AMANDA SCHOLES
PLANNING RECEPTIONIST

I wish to lodge this objection to the developments formally known as P/140.

P/167/21/res

Having looked at the proposed drainage plans.

Drawing Title:
Proposed Soft Landscape Sheet 1 of 3

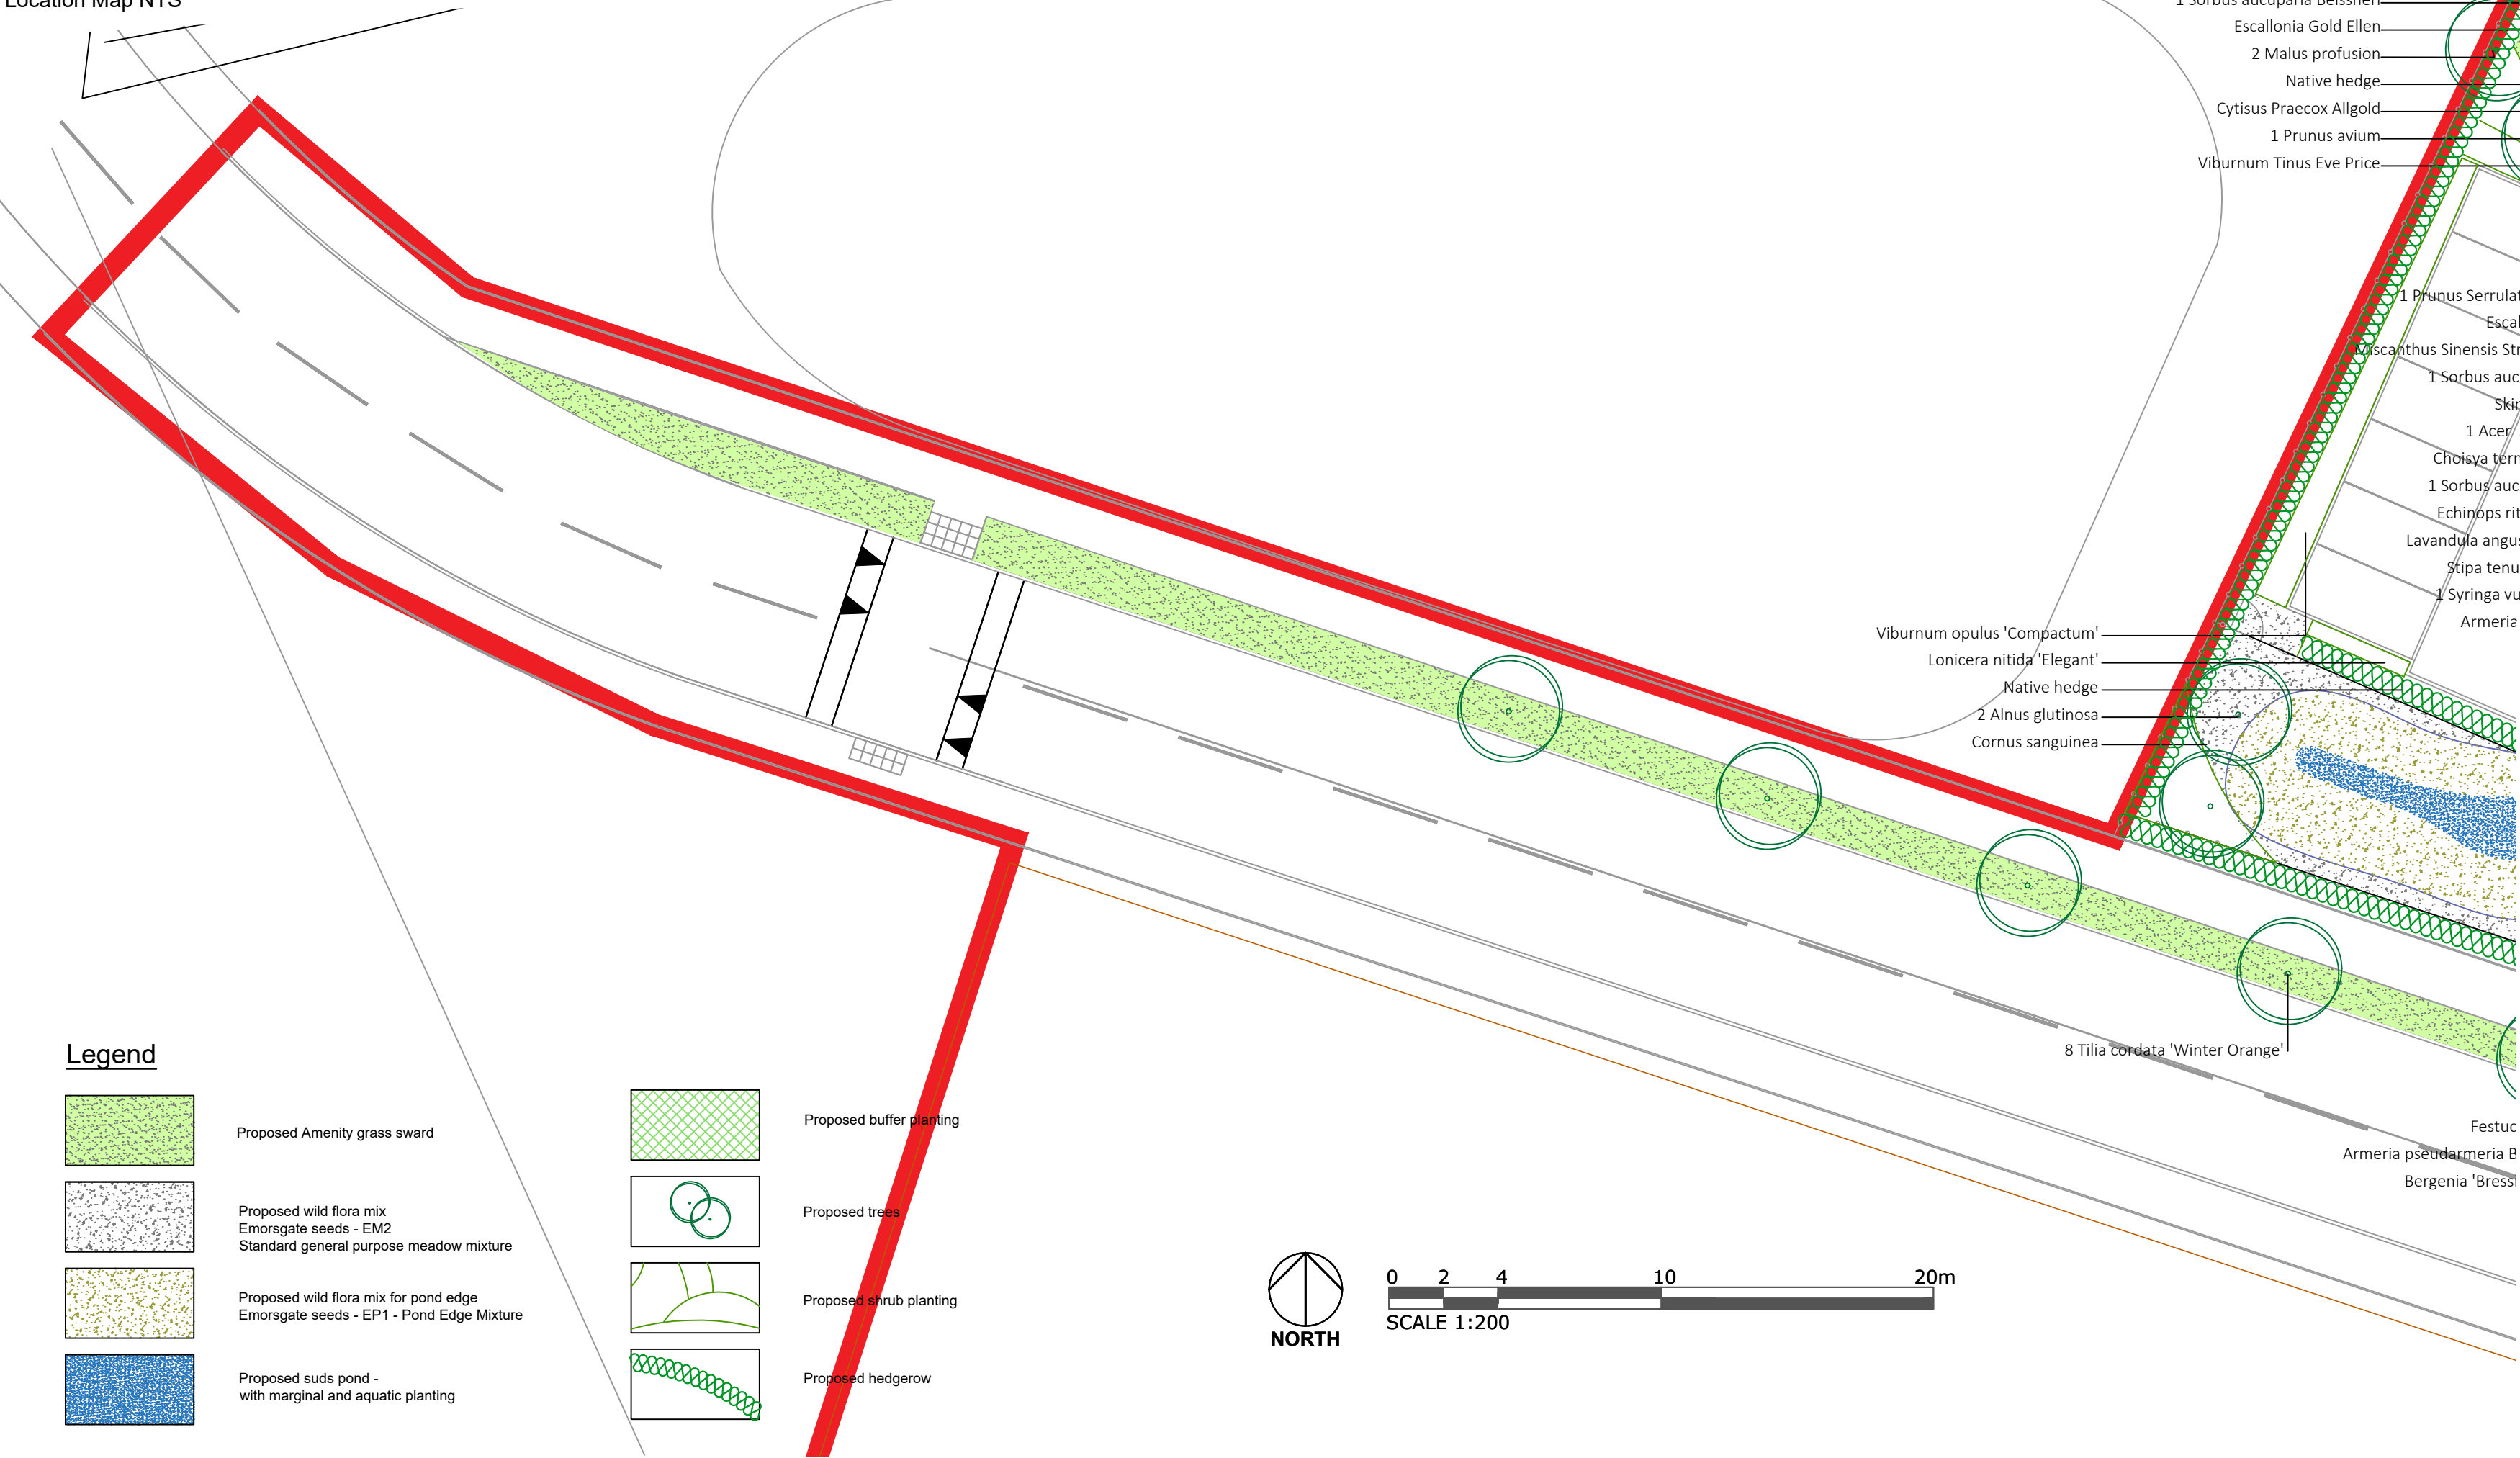
And in my opinion the proposed drainage on all of these developments is not fit for purpose. There are proposed ponds in several locations.but nowhere are there an indication of how they are to be kept safe from young children accessing them.

And the idea of releasing the water from these ponds into the existing ditches is in itself non sustainable as the ditches are many many years old and have never been maintained nor cleaned.

And when first formed would have exited above sea level but sea level has risen considerably since the ditch construction so chances are that they no longer have an exit that is suitable.
